From: Robert Adams
Sent: 26 April 2019 18:48
To: Clare O'Hanlon
Subject: Objection by Robert Adams to Glebe Farm Marina Amendments : 18/00904/F

Objection to Glebe Farm Marina Amendments : Application No. 18/00904/F

PROPOSED AMENDMENTS TO MARINA AT GLEBE FARM CLAYDON

REF. NO: 18/00904/F : APRIL 2019

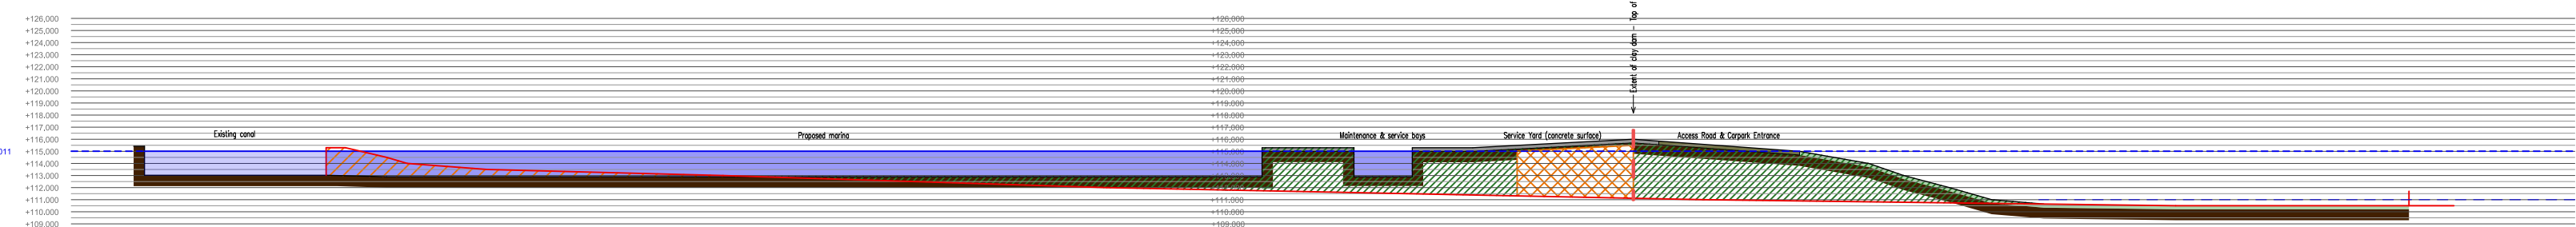
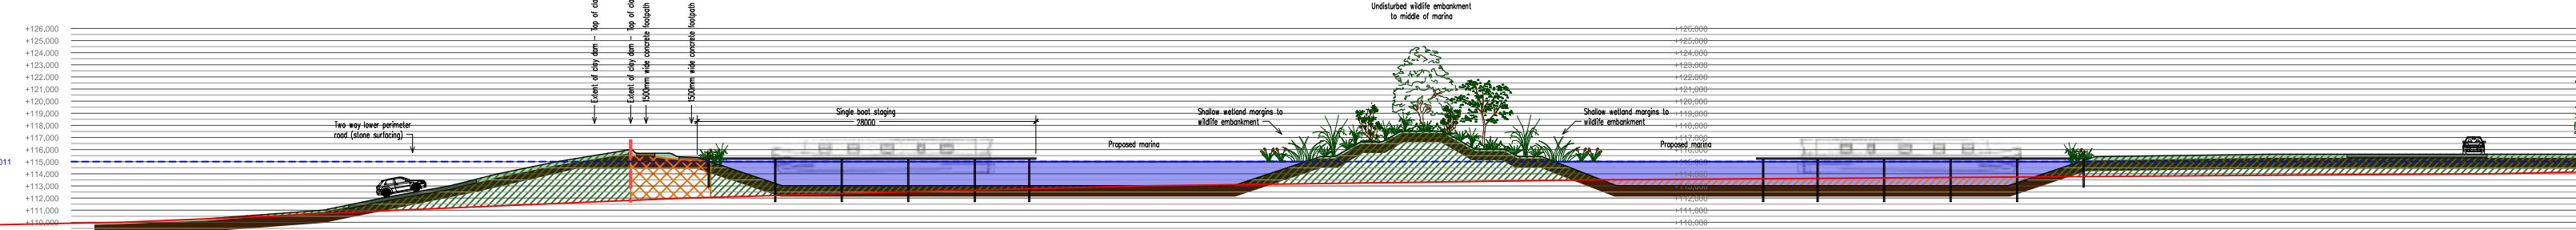
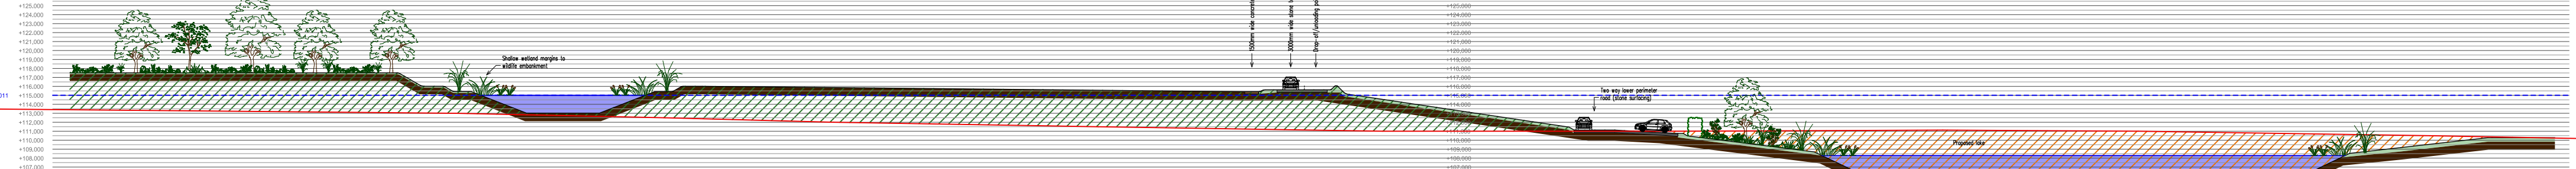
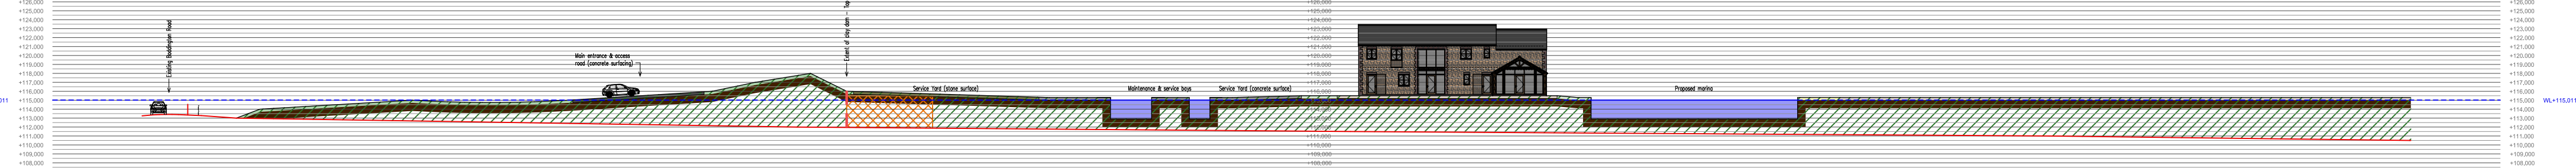
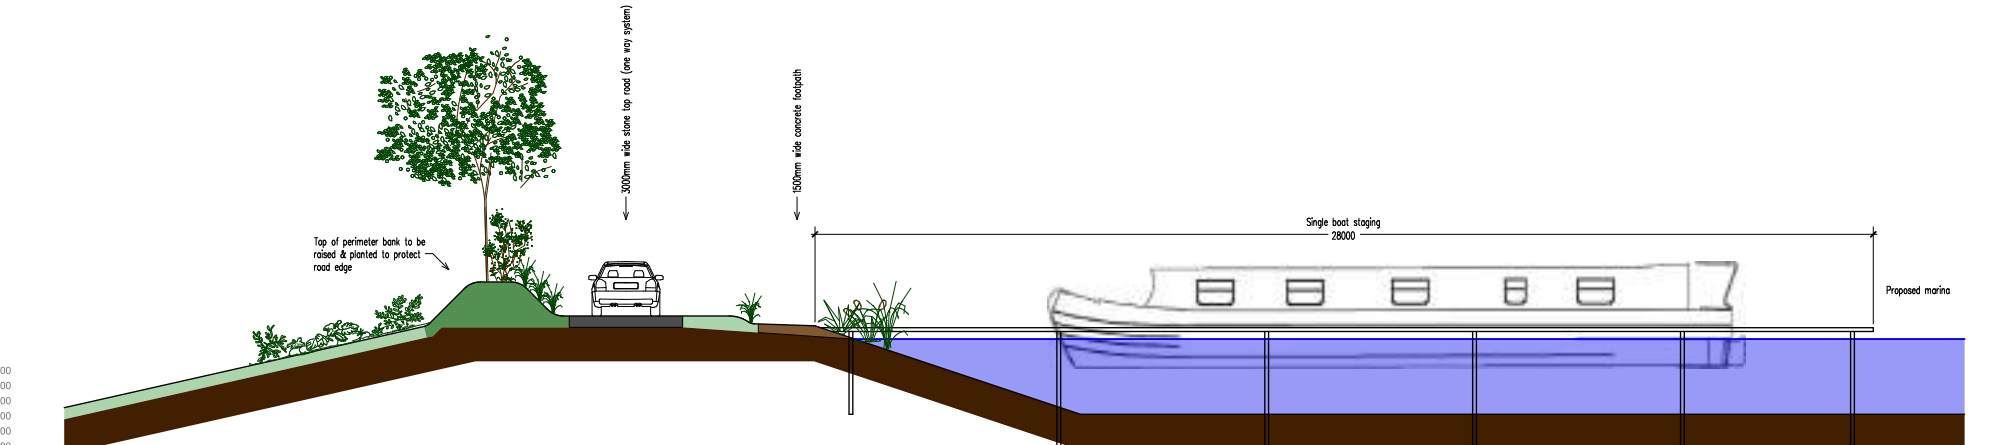
10. I also question the vast extent of earthworks and high banks and bunds that are required to achieve this marina. No consideration has been given to setting the marina at lower ground levels to avoid such high banks. There are no high banks in the district, the canal being elevated approximately only 2m above the landscape along its north side in this location.

I object in particular to the vast volume of soil required for the bank to the east of the Lower Boddington Road near Hay Bridge. This bank starts at the road level of 113.50m and rises to 118m by the maintenance area, i.e. 3 m. higher than the canal and the marina. It would also therefore be 4.50m ($118 - 113.50 = 4.50\text{m}$) or 13.5ft. above the road, completely blocking all the current long views to the east through gaps in, or over, the existing hedging. In addition, tree planting is proposed all over this high bank, further shutting down this wide-ranging valuable local view.

This bank, topped with a 3m high bund, which continues all around the marina, is placed on top of the proposed banks. This smaller bund is not part of the general slopes of the banks but is added on top of them. What is its function? Is it for flood control? The Canal and River Trust has not commented on this, and there is nothing in the reports that explains why this additional 3m high bund has been added. Is it in fact needed? In effect, I object strongly to the vast earthworks and banks that are proposed for this marina, which are in total contradiction to the gently sloping character of the landscape and the low banks supporting the Oxford Canal.

The bank proposed along the north side of the site is even higher when seen in combination with the bank along Harefurlong Brook. Levels in the brook are lower (107.70m) and the top level of the bank is 115.50, which is the level of the marina perimeter road, i.e. a change of level of 7.80m. i.e. 25.50 feet. Adding the 3m bund on top, the height would increase to 10.80m or 35ft. or higher than a two storey house! In views from the canal, this would

12. I also object to the creation of the proposed lake 7m below the marina level. There are therefore two water levels, the marina (115.0m) and the canal, and the lake (108.0m). Although from the site layout it looks as though the marina and the lake are at the same level, it is only when the levels are examined in detail, it is realised that they are not related because they are at very different levels. Also, the levels on the drawings are very indistinct, almost illegible, because they are printed in blue on a blue background and are in very small type. It transpires that the lake is separated from the marina by a 5m high grass bank.

The banks would be in two sections. The first bank is for the lake and is the lower, rising 2m high above water level. This is the level of the marina ring road (110.0m) and the car parking areas. The second is the long, upper bank, 5m high, up which owners would have to climb to get to their boats (115.0m). These western banks face due east and would be visible from public footpath 170/6/20, changing the nature of views to the west by cutting off **all** views,

and, incidentally, the marina. The view from this footpath therefore would, by destroying the existing long view, offers no enhancement of the landscape to walkers along the public footpath. Additional 7m banking is needed at the canal (southern) end of the lake (water level 108.0m) and the canal level (115.0m), and again these levels are not detailed on the drawings.
